REQUEST

Current Zoning: ML-2 (Manufacturing & Logistics 2)
Proposed Zoning: IMU (CD) (Innovation Mixed-Use, Conditional)

Approximately 3.44 acres located on the west side of Westpark Drive, east of Interstate 77, and south of Tyvola Road.

PLANNING STAFF REVIEW

Dwg No.
**REZ
1.0**

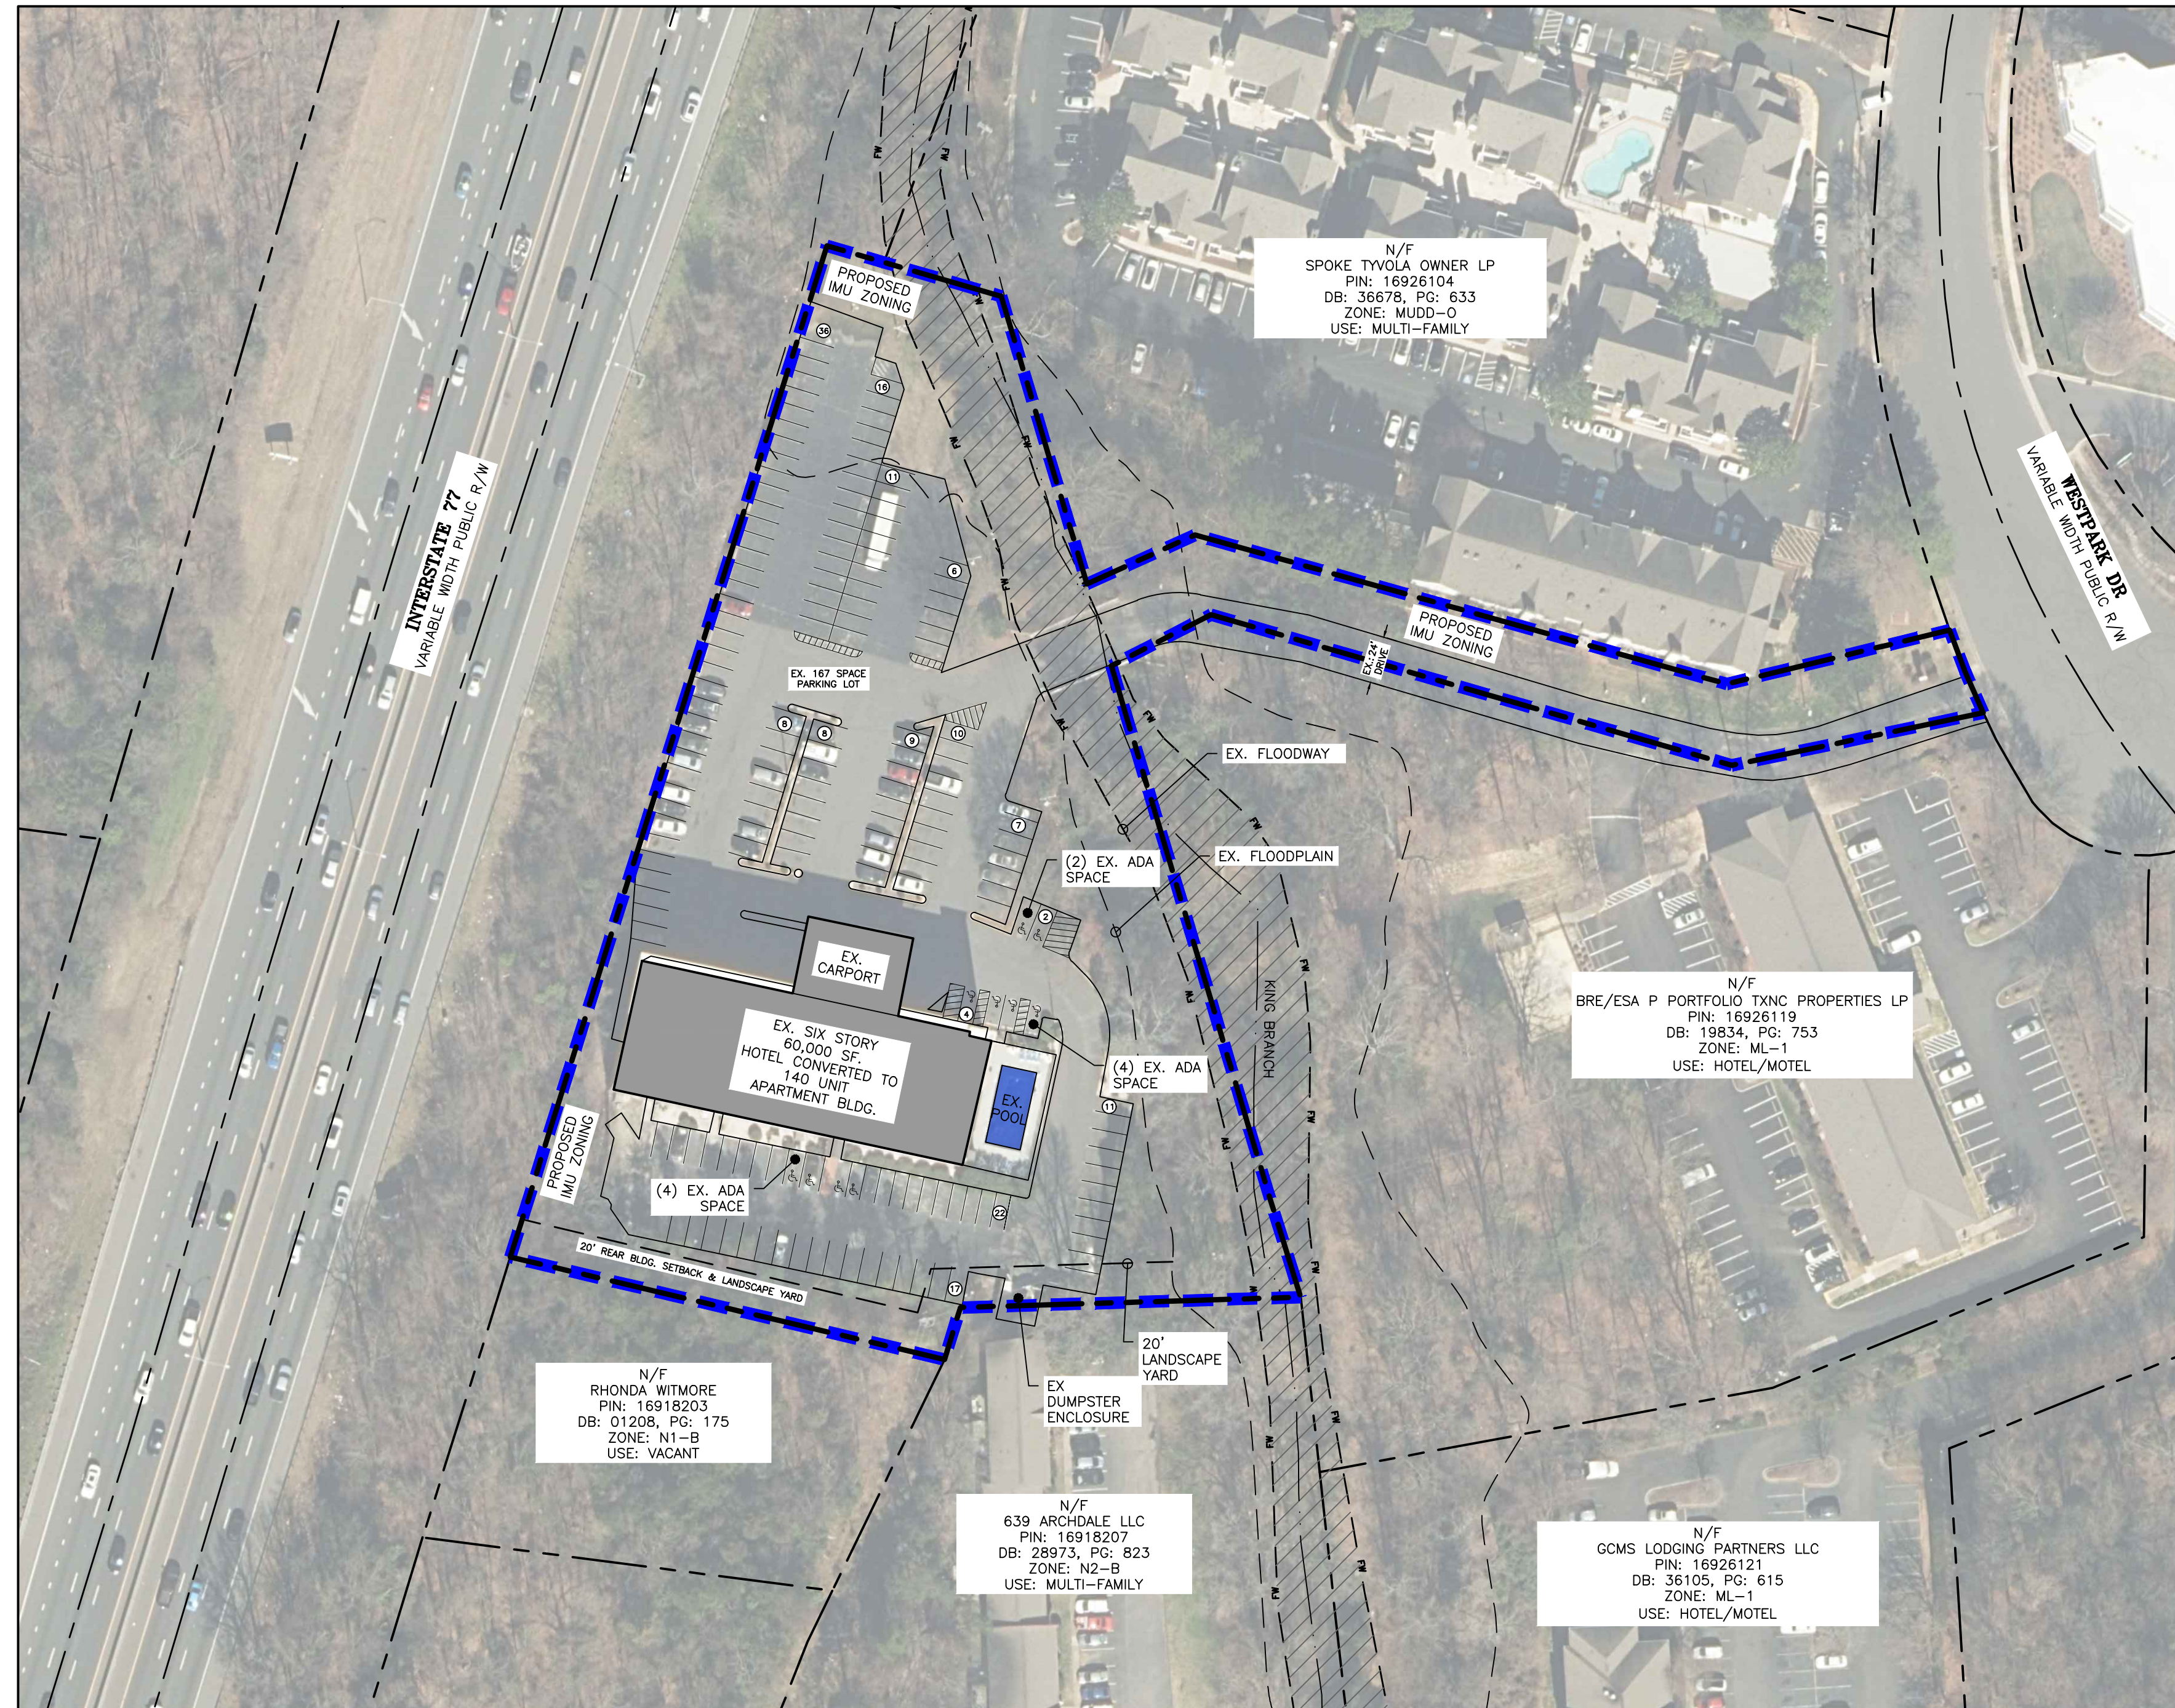
3. ~~MCPR requests the petitioner dedicate and convey a greenway and storm water easement to Mecklenburg County which would include whichever is larger of the 100' SWIM Buffer or the FEMA Floodplain of Kings Branch for a future connection to Kings Branch Greenway Trail. The easement can overlap the tree save areas and the existing paved driveway; however, the easement area should exclude the existing paved parking areas. The easement should be conveyed prior to the first CO. Revise site plan to label easement area as "stormwater and greenway easement" and add conditional note referencing the stormwater and greenway easement.~~ **ADDRESSED**

Dwg No.
REZ 3.0

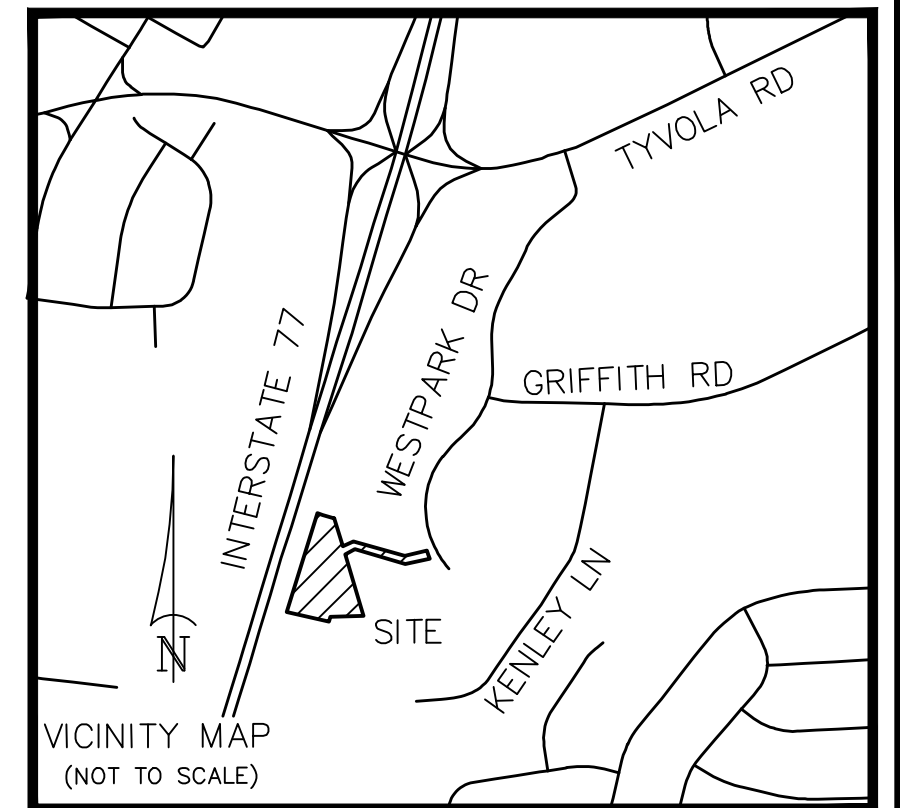
6. ~~Provide a conditional note that lists amenities to be provided in open space.~~ **ADDRESSED**
